11 December 2019

**NSW Department of Planning and Environment  
New Primary School at Warnervale – Traffic Engineering Statement**

Stantec has reviewed the comments register dated 28 November 2019 (*CPS comments – 191128 – Response to Submission Tracker – Warnervale*) and has provided responses in the following response table:

CLIENT  
DEPARTMENT OF EDUCATION  
DRAWING TITLE:  
GENERAL ARRANGEMENT -  
MAIN SCHOOL ENTRY

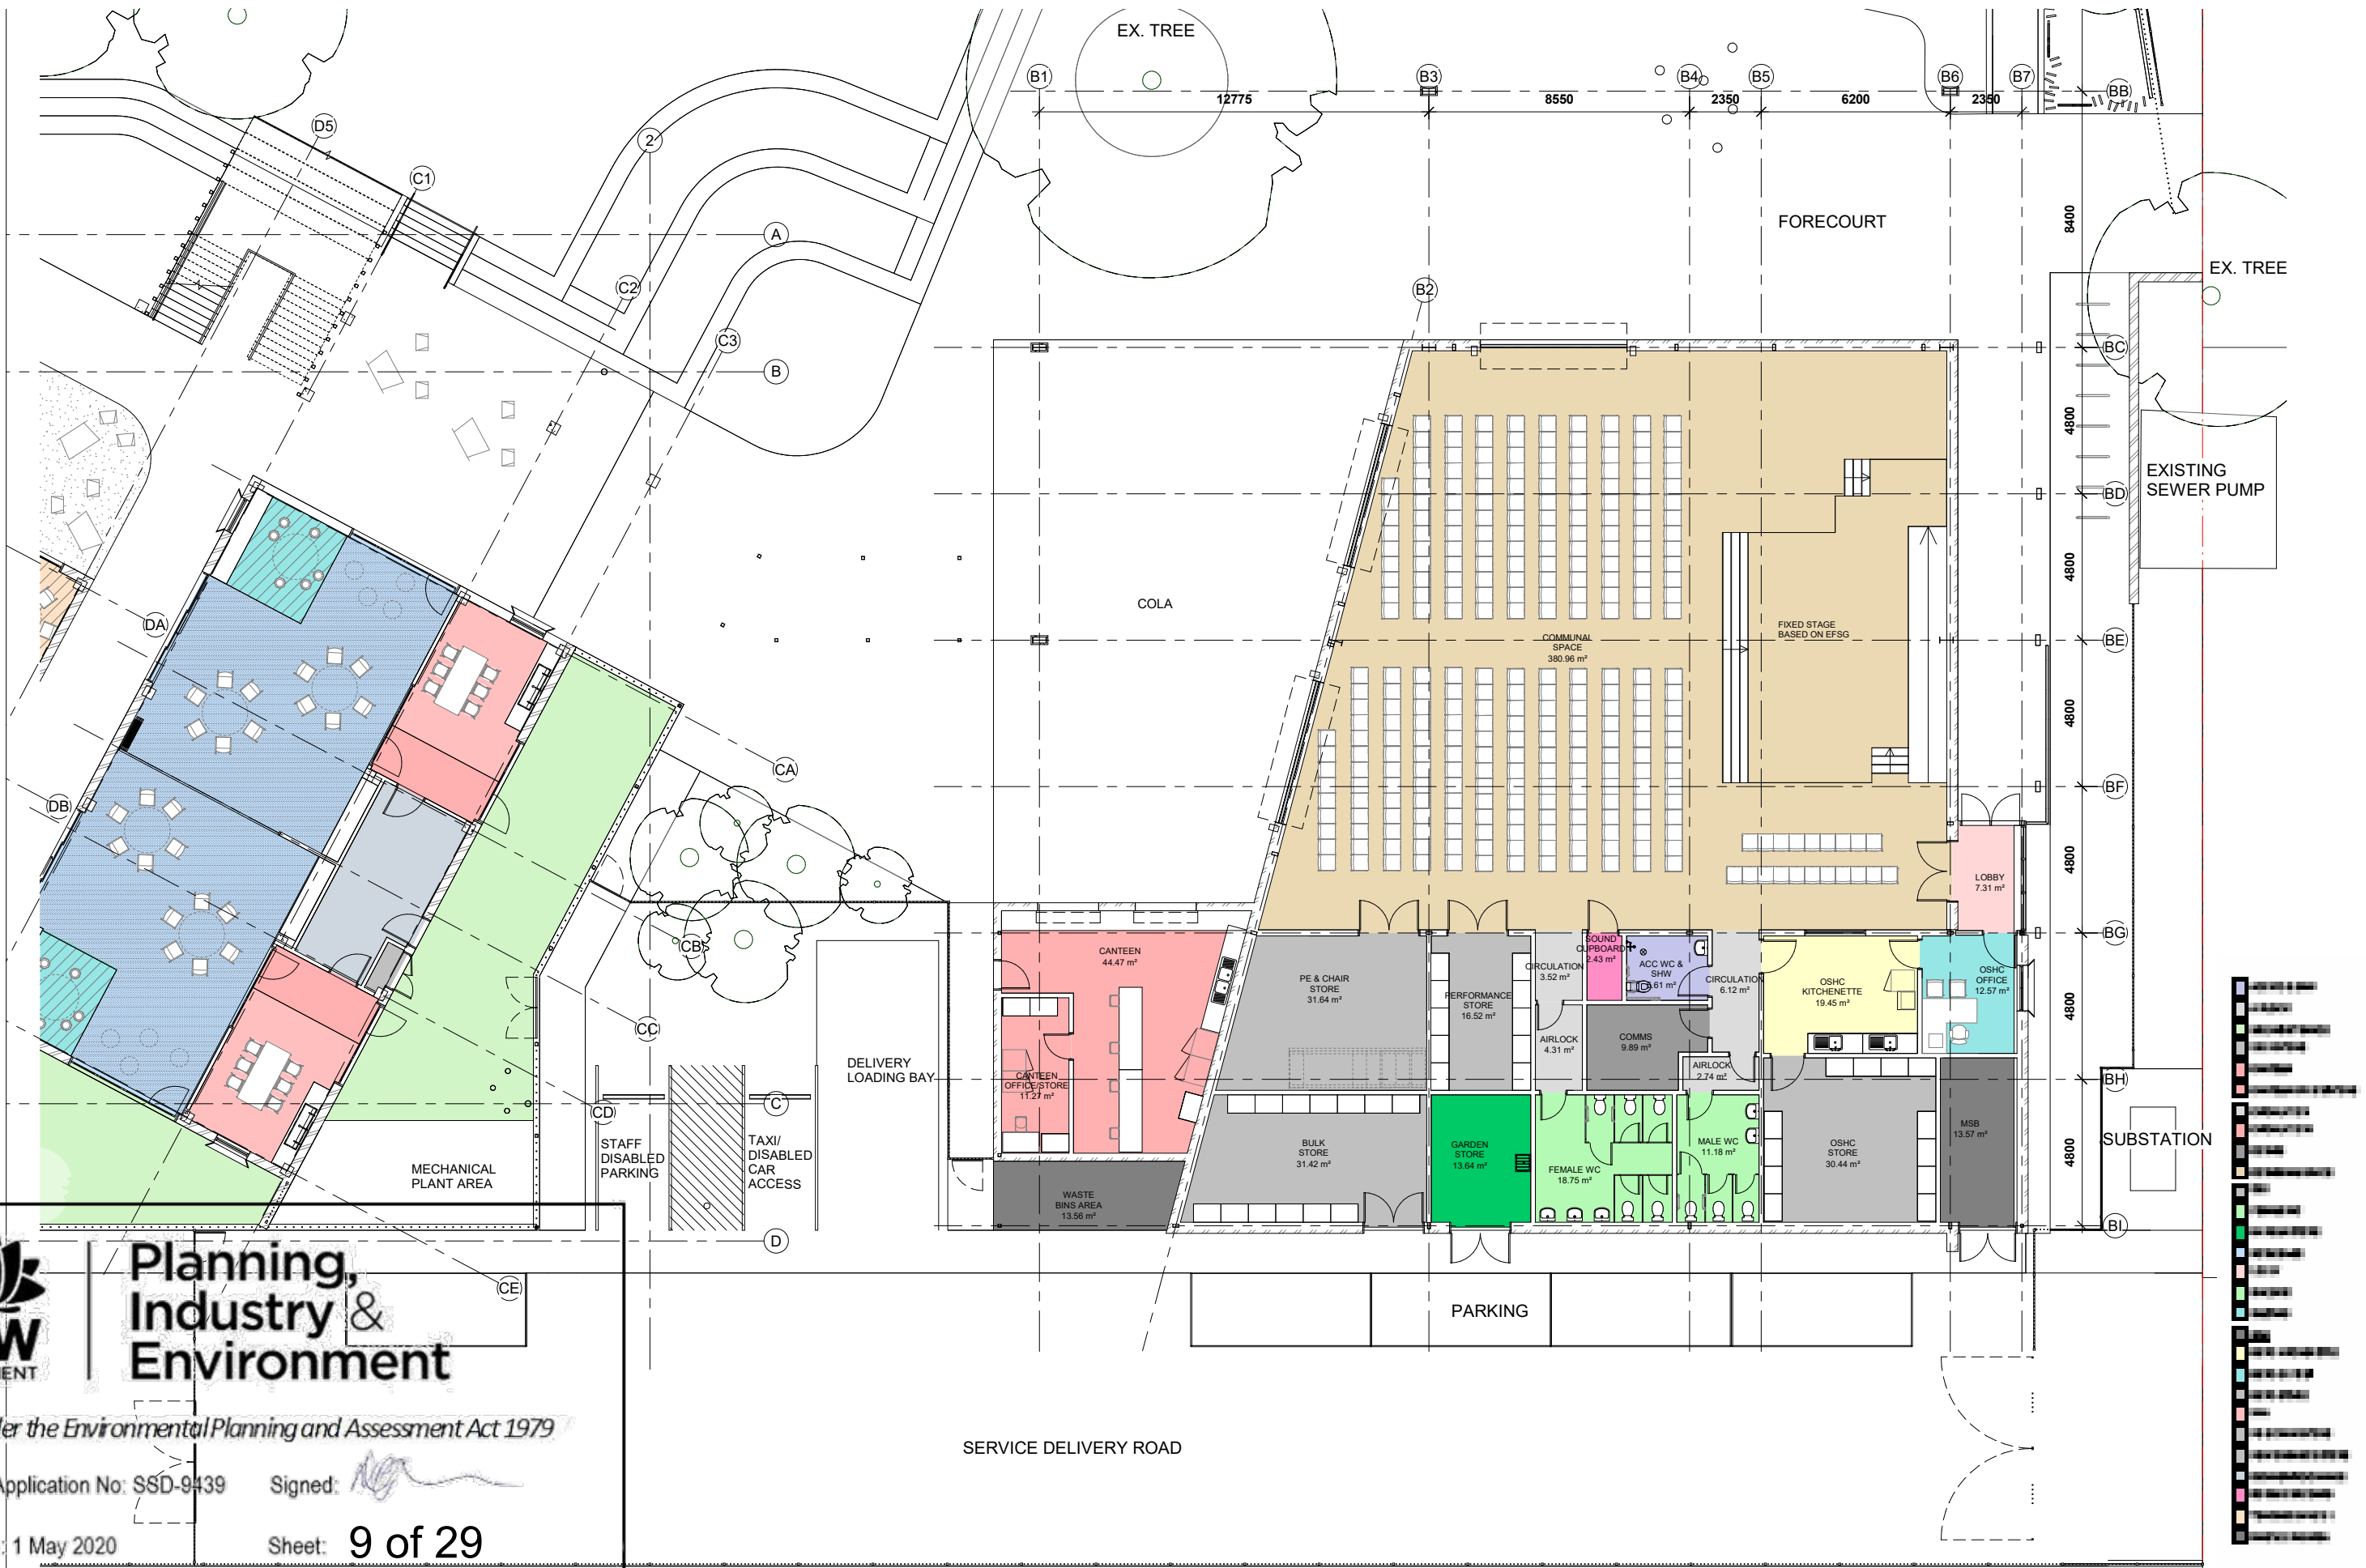
| 9  | Redesigning road access to give greater priority to pedestrians at main entry.   | <p>The proposed design is considered sufficient in providing priority to pedestrians at the main entry.</p> <p>Redesigning the road access might be excessive and possibly lead to a similar outcome; however, the following can be carried out to provide greater priority to pedestrian and raise awareness to drivers:</p> <ul style="list-style-type: none"> <li>• Review speed environment of Warnervale Road, as well as the school frontages;</li> <li>• Provision of appropriate signage, speed humps and raised crossings, if necessary.</li> </ul> |
